From: wilpshire parish council <wilpshireparishcouncil@gmail.com>
Sent: 28 April 2024 09:42
To: Planning; wilpshire parish council
Subject: planning application responses from Wilpshire Parish Council

Wilpshire Parish Council would like to comment as follows:

3/2024/0126 9 Berkshire Close Wilpshire – 2 storey extension to rear, single storey extension to side and new first floor window to side

PROPOSED: FLOOR PLANS AND SITE PLAN

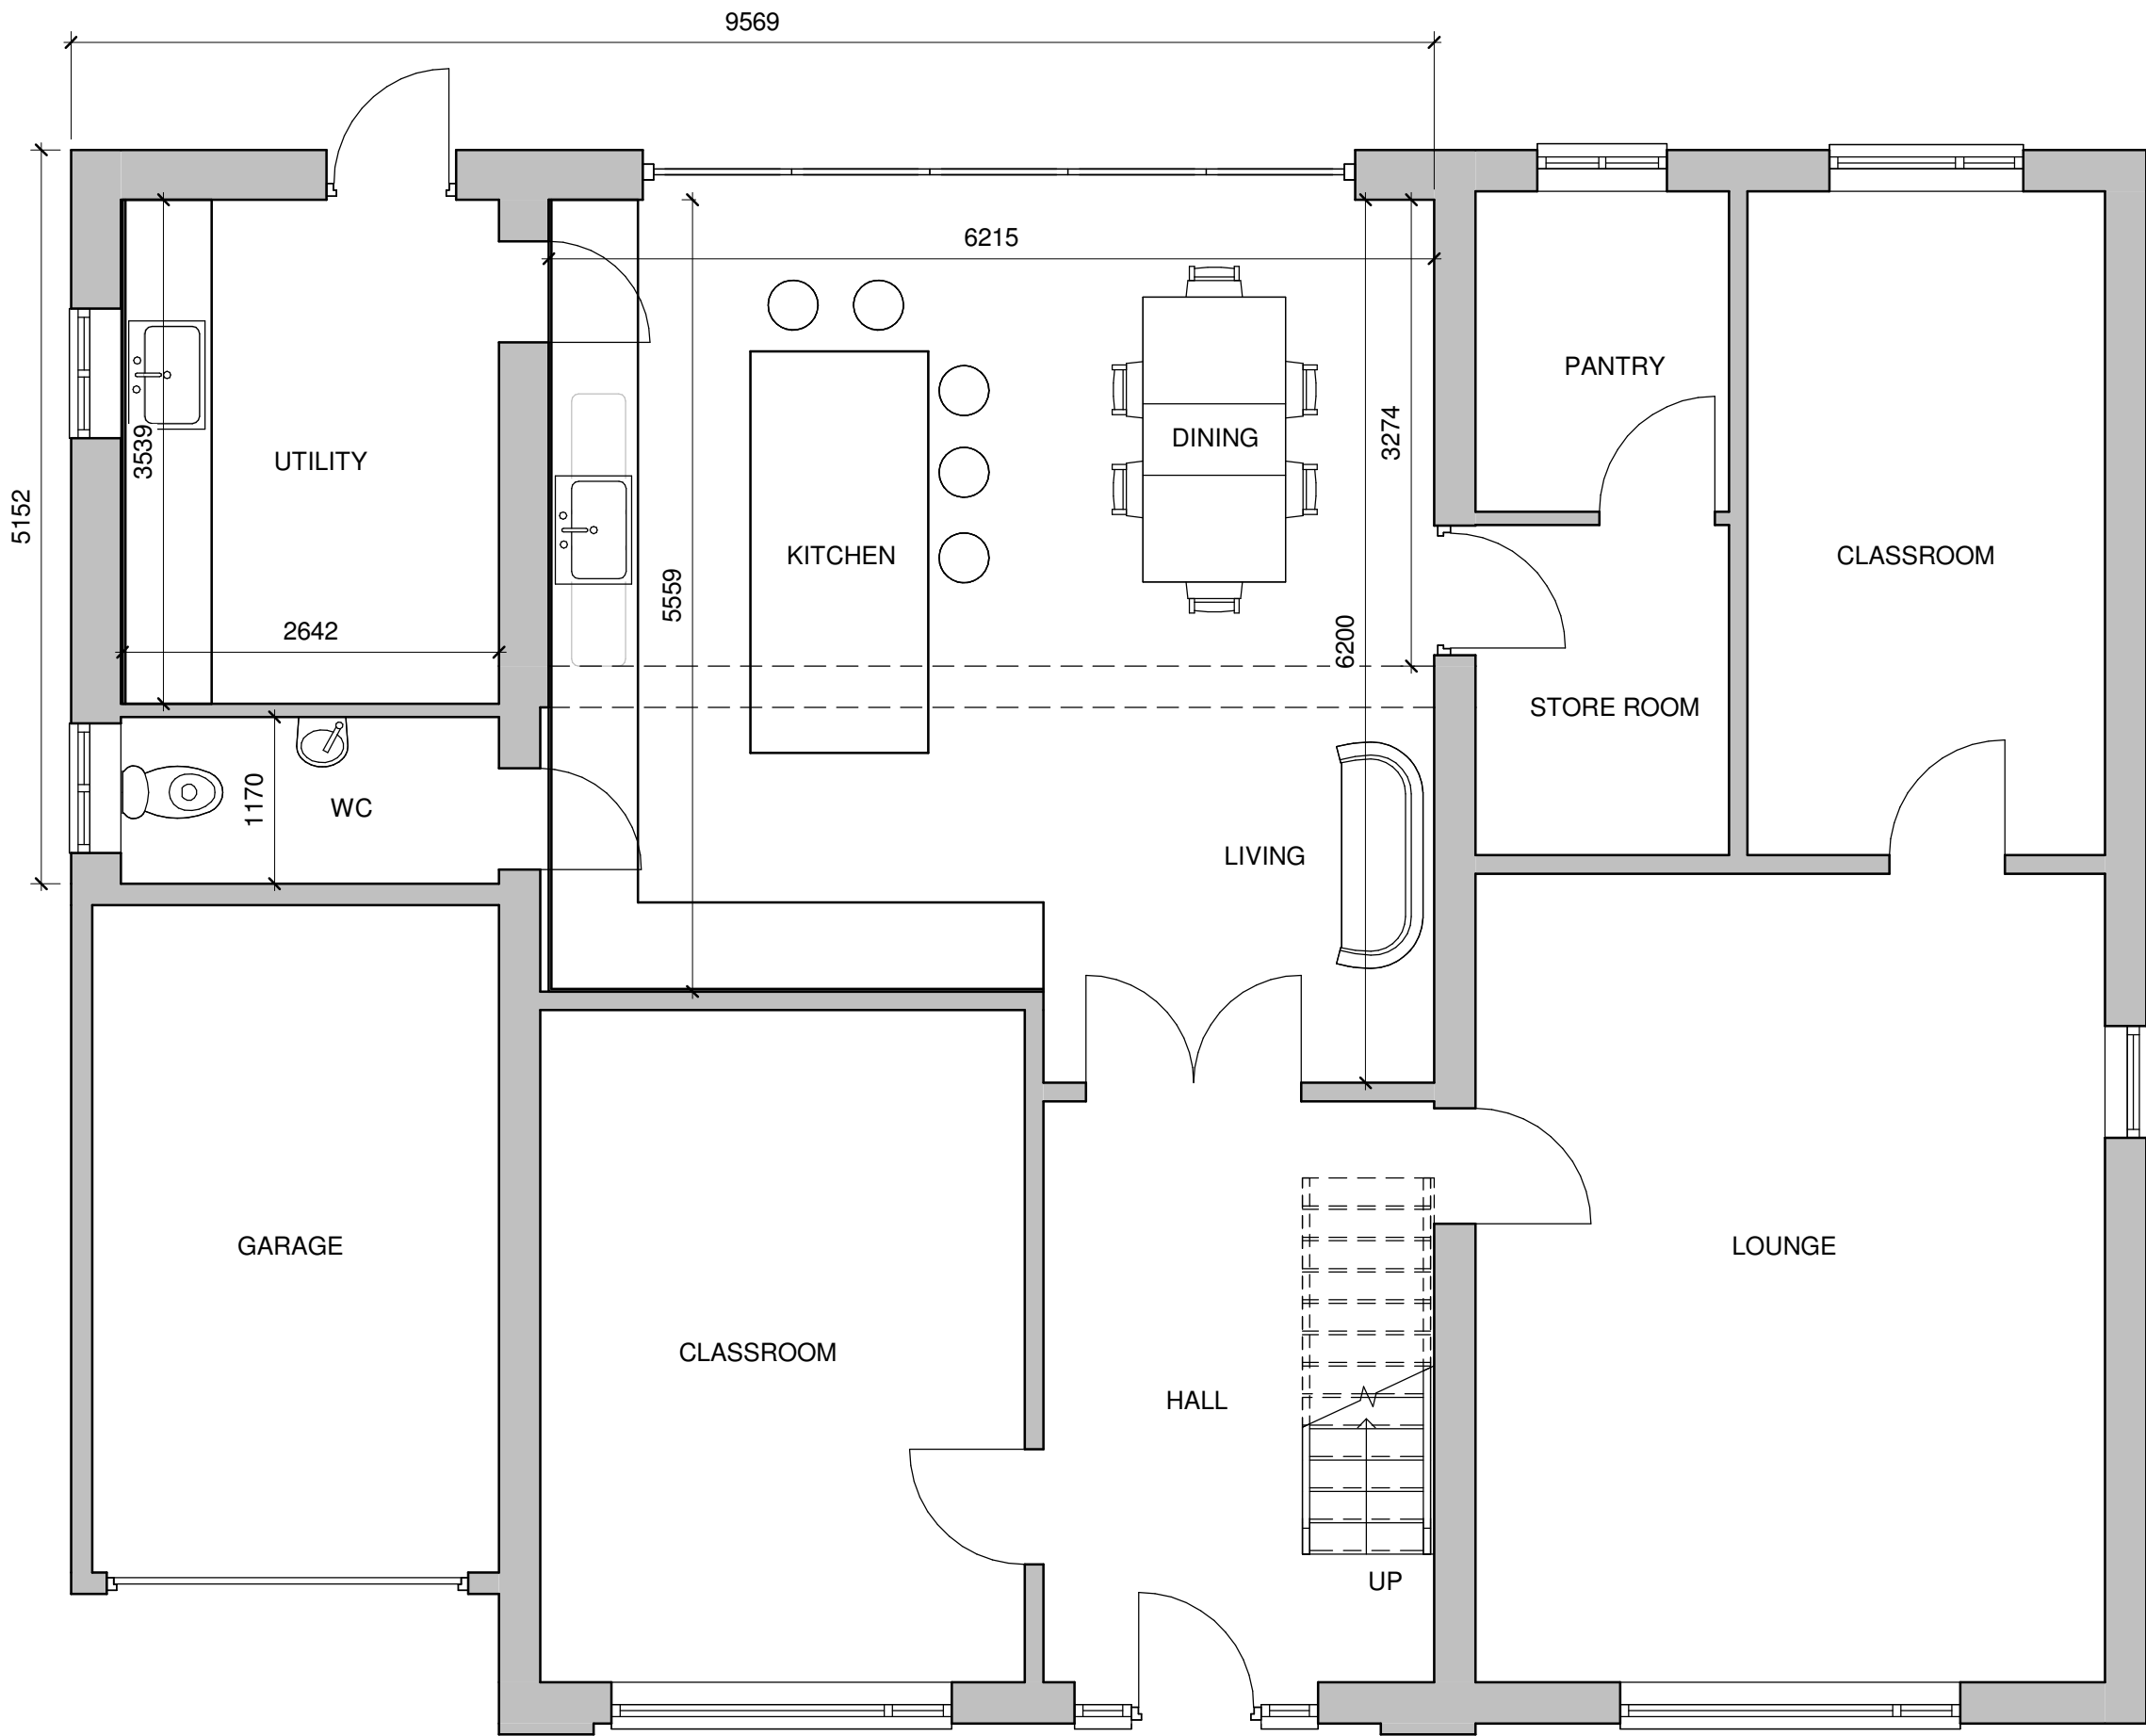
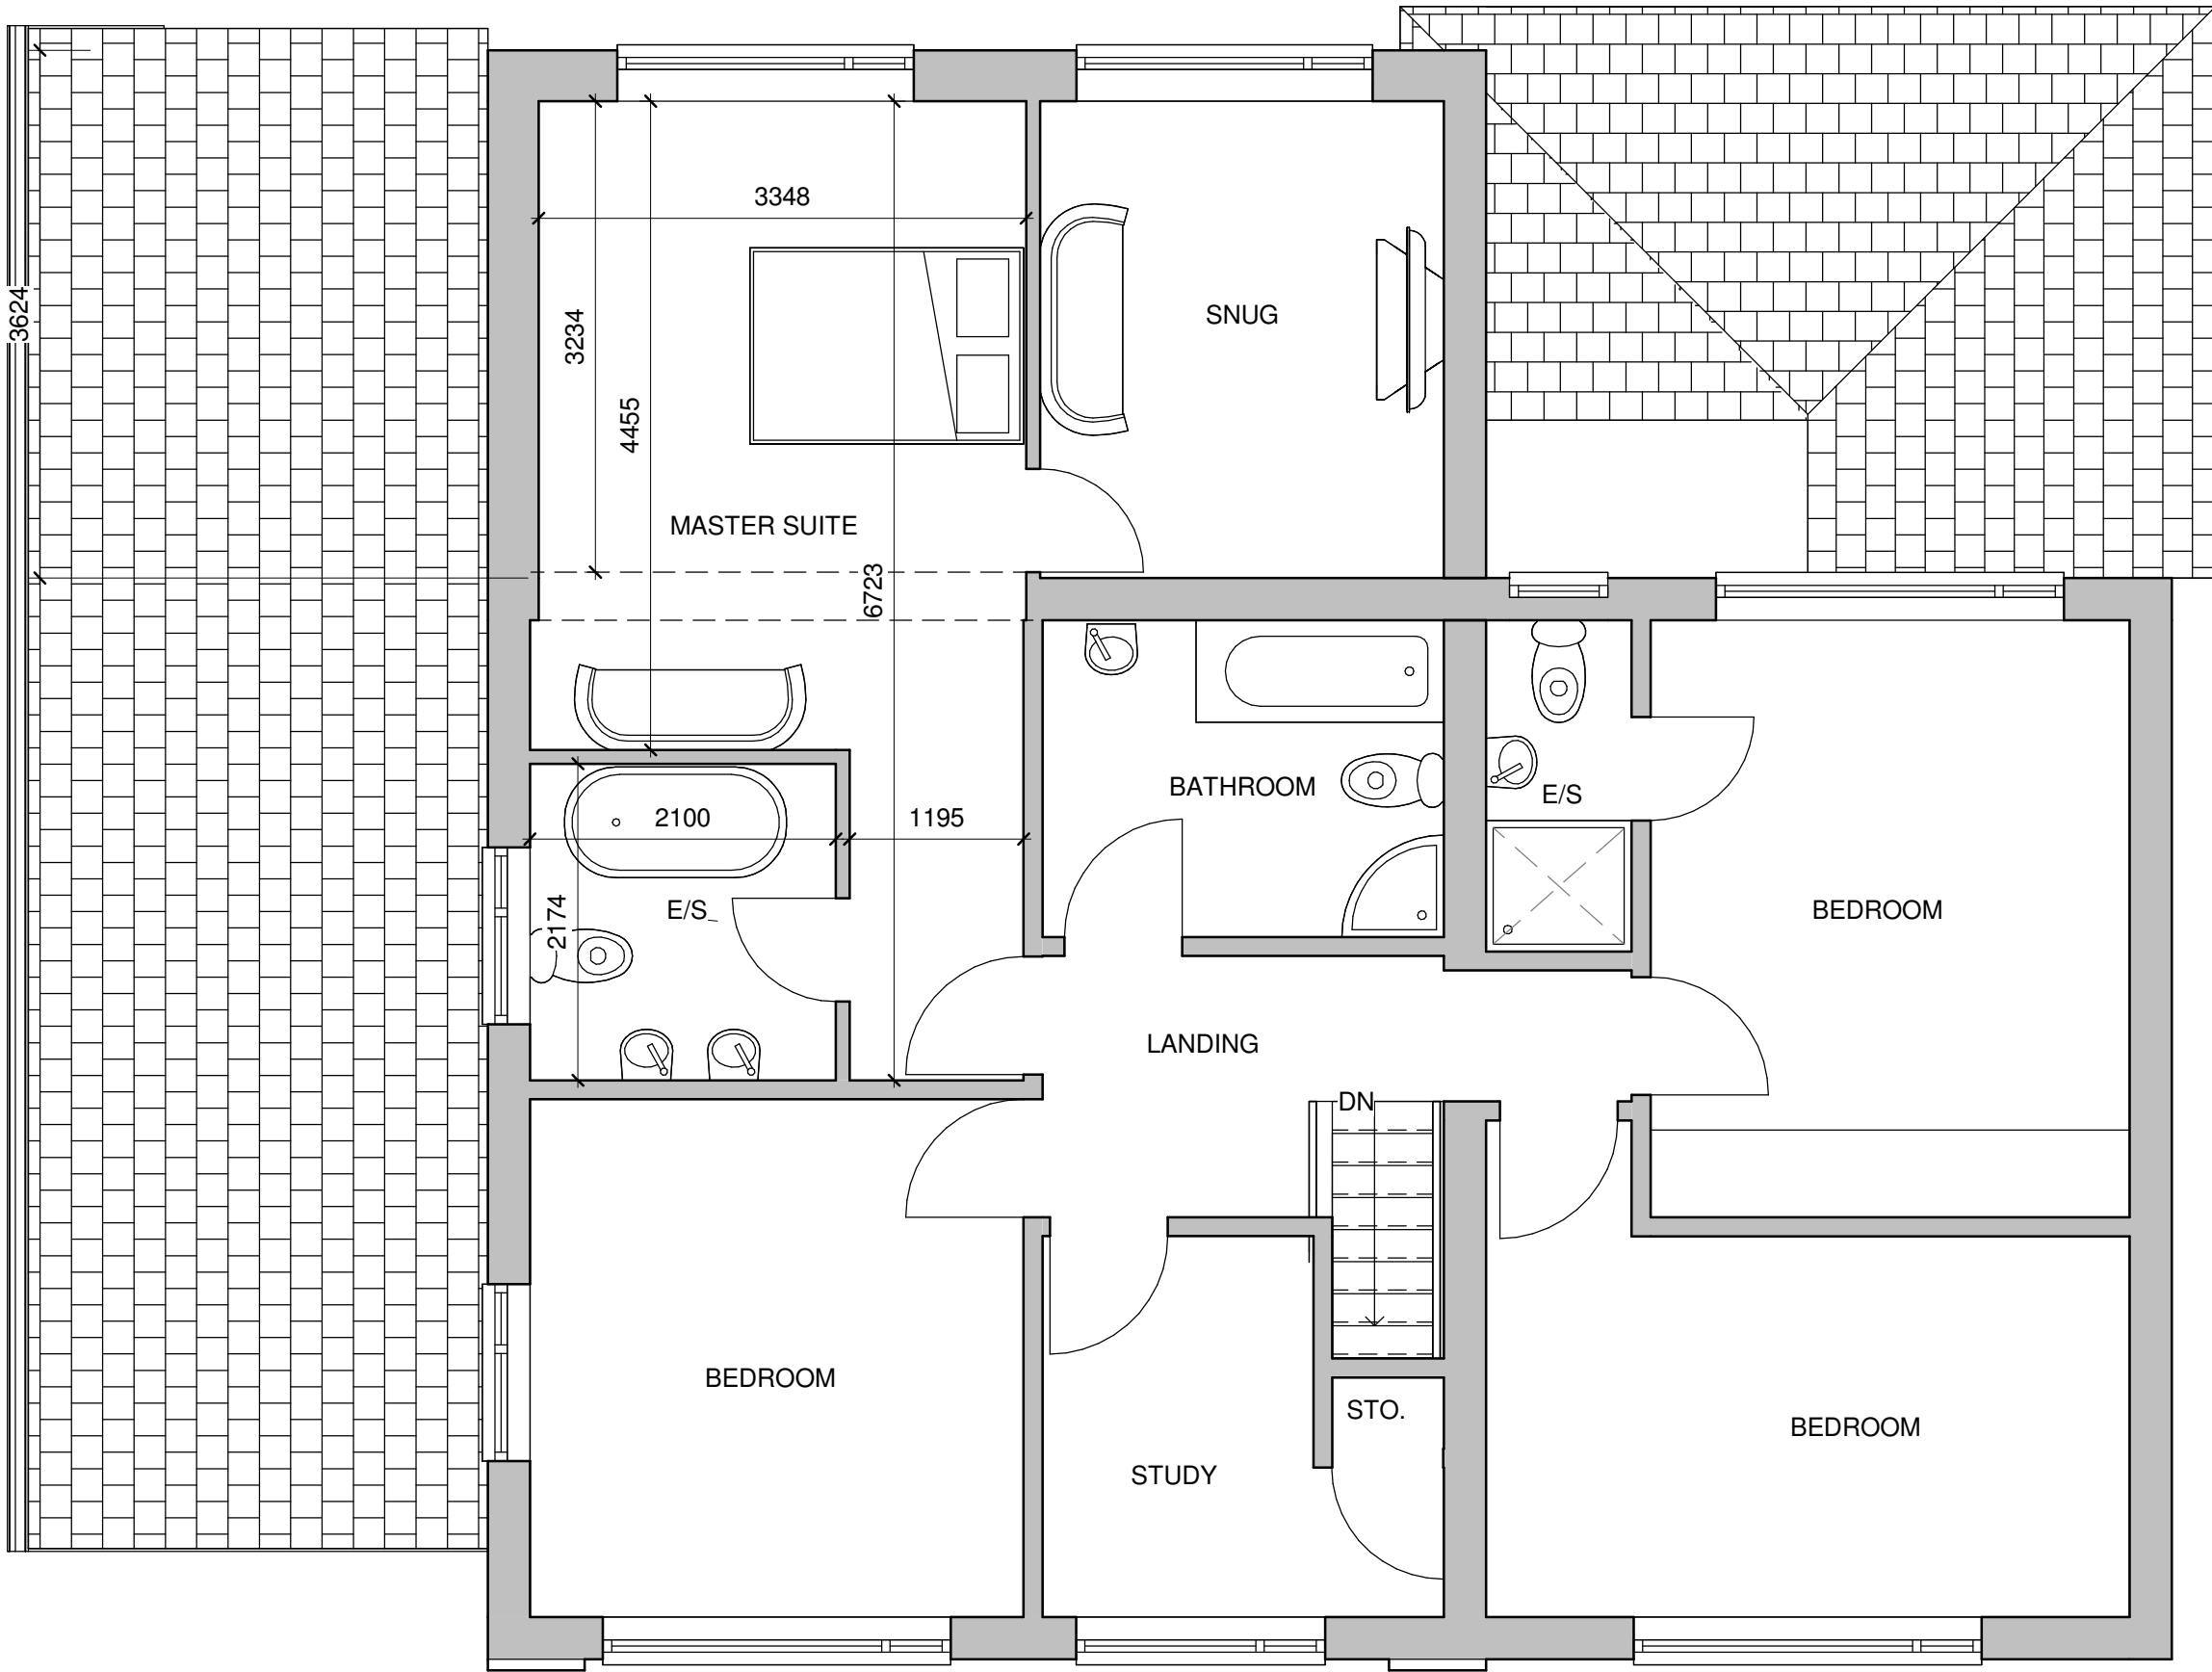
WPC – Before response is seeking clarification of the 2 x classrooms annotated on the plans from the planning officer.
